CITY OF ALBUQUERQUE

May 8, 2024

RE: 845 Juan Tabo Blvd NE
Grading & Drainage Plan
Engineer's Stamp Date: 04/29/24
Hydrology File: K21D019

Based upon the information provided in your submittal received 04/30/2024, the Grading & Drainage Plans **are not** approved for Building Permit, Grading Permit and SO-19 Permit. The following comments need to be addressed for approval of the above referenced project:

845 JUAN TABO BLVD., NE GRADING AND DRAINAGE PLAN

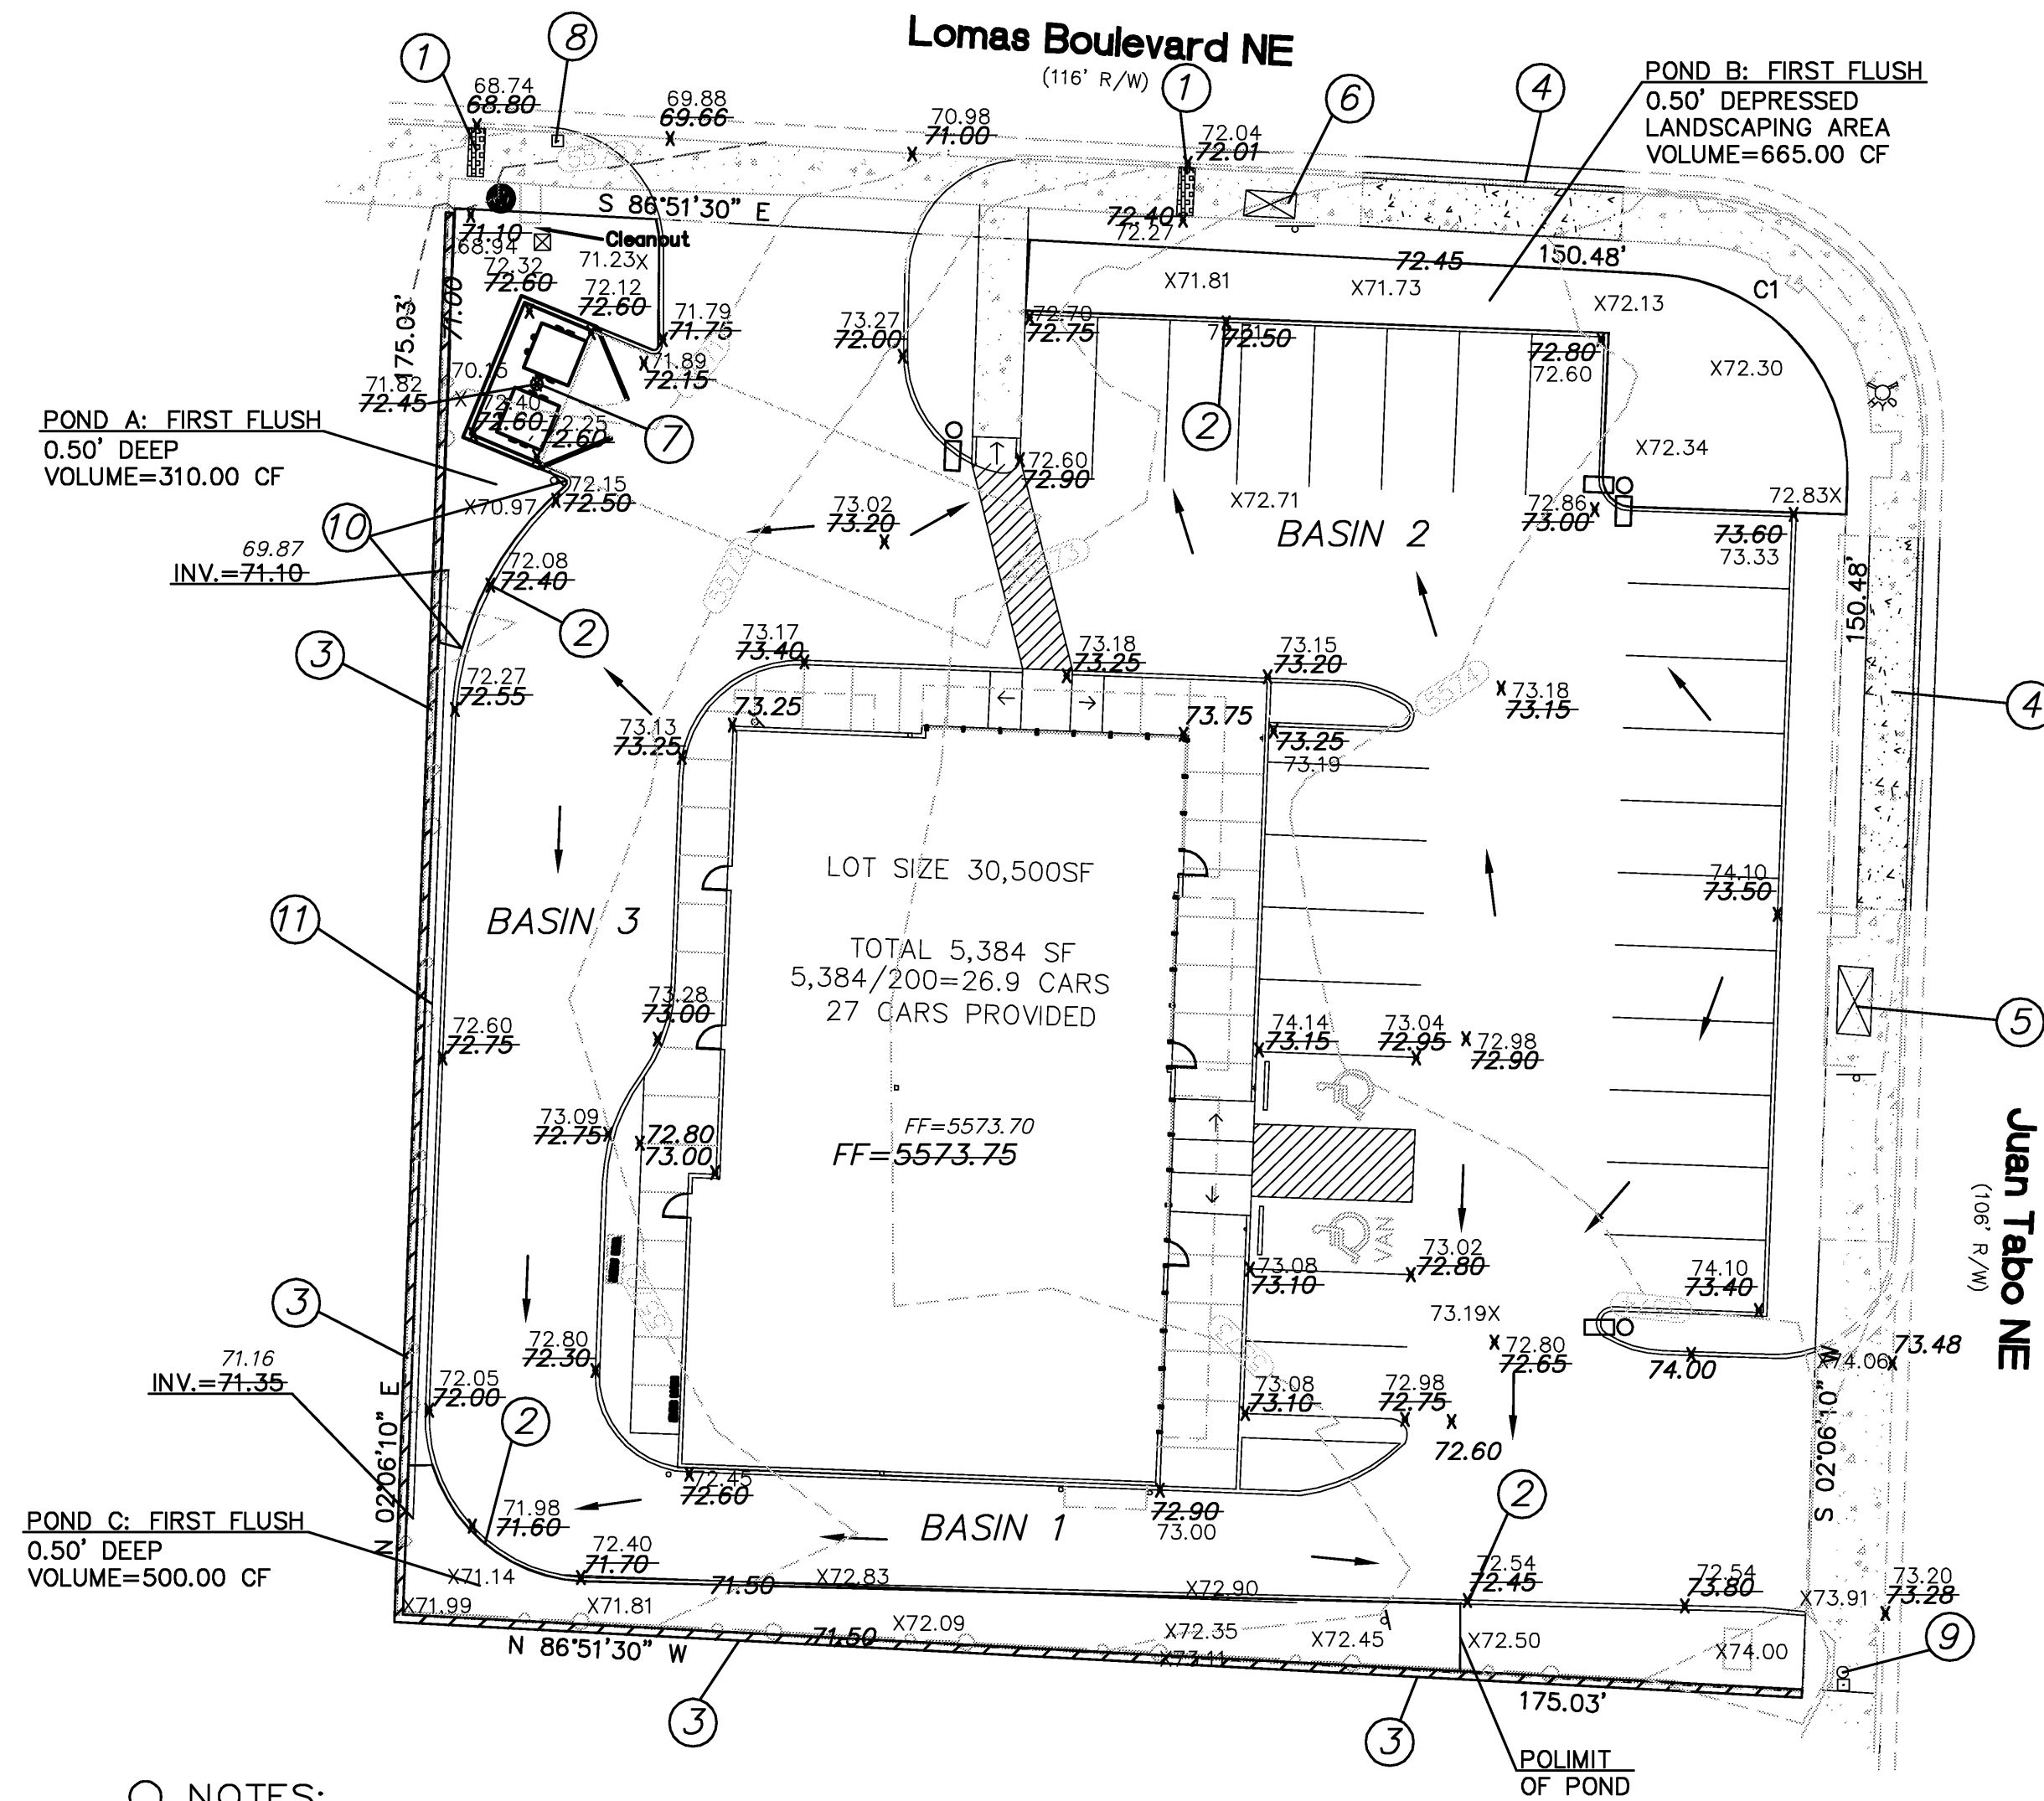
1. Please show the closure the two drive pads at the Northeast corner of the property. One is on Lomas and the other on Juan Tabo. Both need to show both proposed curb & gutter and proposed sidewalk.

2. Please show the existing bus stop on Lomas. Also, please contact Transit, they may want this to be upgraded to be similar to the other on Juan Tabo.

3. Please show the top of the Stormwater Quality Pond at the Northeast corner of the property. Cannot tell if there is enough volume as indicated. Also, it appears that the sidewalk culvert is at the location of the bus stop. This may have to be shifted over to the west.

4. The proposed entrance on Juan Tabo needs some attention. First the existing drive is a driveway and does not have a proper curb radius per CoA paving detail 2426. Second, the other radius has to become tangent before the property line. This cannot encumber the adjacent property owner. Please fix. And third, please show the existing power pole that is near the property corner.

5. Please show the existing light pole on Lomas at the Northwest corner of the property.

6. Is there a reason why the drive-thru lane is not the same width? It is about 13 feet wide at the west corner of the building and about 12.2 feet wide at the eastern corner.

7. Please show the top of the Stormwater Quality Pond at the Northeast corner of the property. Cannot tell if there is enough volume as indicated.

8. Not sure how the Stormwater Quality Pond A is to drain to Lomas. The space that is there is only 1.5 feet wide which is not wide enough to build a swale 0.5 feet deep. This will need to be a minimum of 3 feet wide.

9. For trash enclosures serving food service developments, trash enclosures must demonstrate control of liquids from dumpster areas per DPM by containing runoff from the dumpster area, preventing outside drainage from entering the dumpster area, and discharging to the sanitary sewer. Please show an inlet in the middle and label. "Inlet to be connected to the sanitary sewer. See Utility Plan."
